From: Amanda Scholes on behalf of Planning.Responses
Sent: 09 March 2017 08:37
To: Planning Scanning
Subject: FW: Planning Consultation on: Y/5/17/OUT
Attachments: Drainage - Supplementary Guidance Notes.pdf

Engineers comments in respect to surface water drainage:

APPLICATION Y/5/17/OUT

Site Address: Cinders Nursery & Land R/O Cinders Lane Yapton BN18 0JJ

DWG N^o: HP16098 003
Conceptual Layout 003a

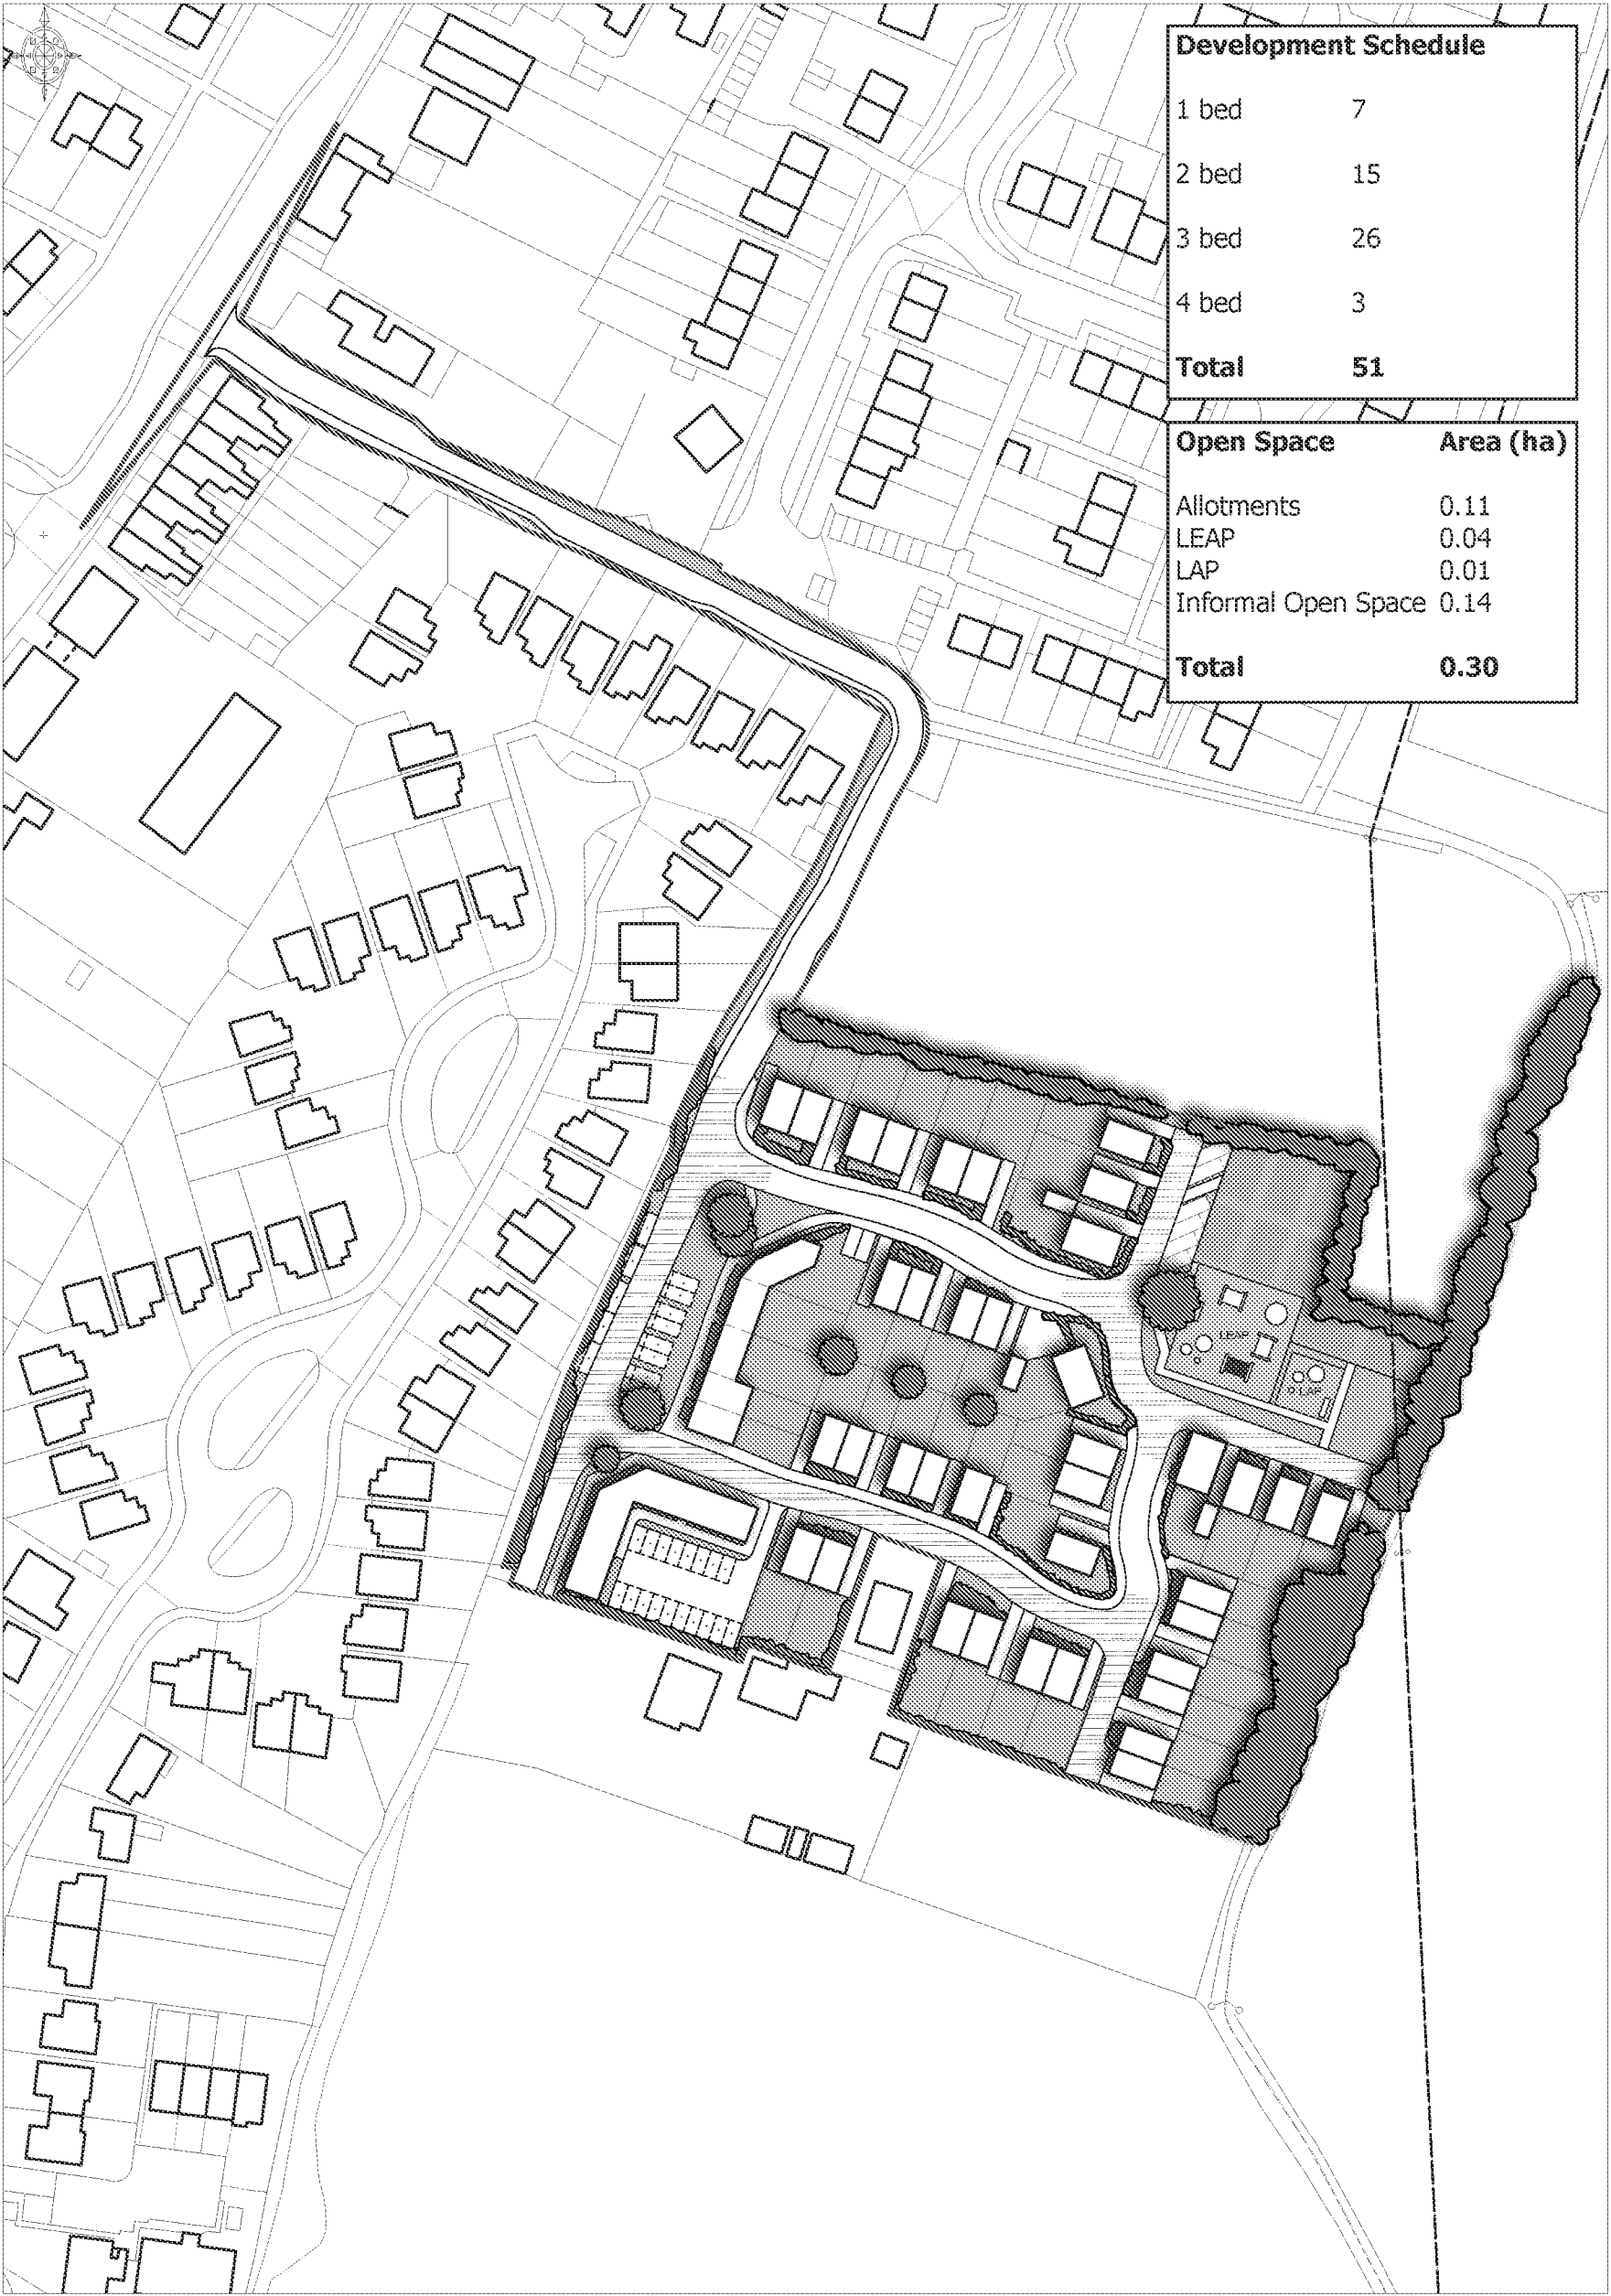
Surface water to be discharged to SuDS system. A culvert is proposed to reconnect a partially filled ditch with a functioning ditch. This will be required and should have an easement equivalent to that provided for the ditches. For large flat sites the focus should be on shallow attenuation with infiltration if possible. Easements should apply to all ditches, watercourses and culverts. Attenuated discharge to watercourses or surface water sewers are technically feasible for this site, as stated in the drainage strategy. We have discussed the above with the applicant and consultants.
